Application for a non-material amendment following a grant of planning permission. Town and Country Planning Act 1990

Land adjacent D Brown Building Contractors, Seas End Road

Change of use of 6 holiday lets to one single dwelling.

North West Elevation

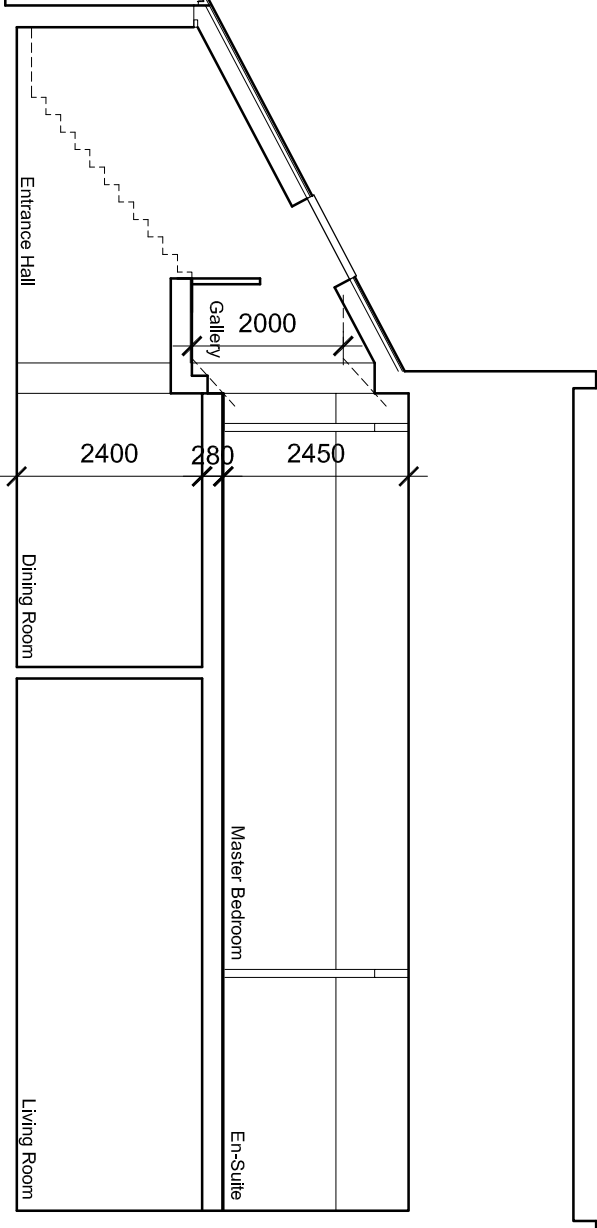
To north-west (rear) elevation, omit 2 no. rooflights and replace with combined rooflight / wall window (Velux type) to facilitate means of fire egress.

Provision of fire egress window to comply with Building Regulations.
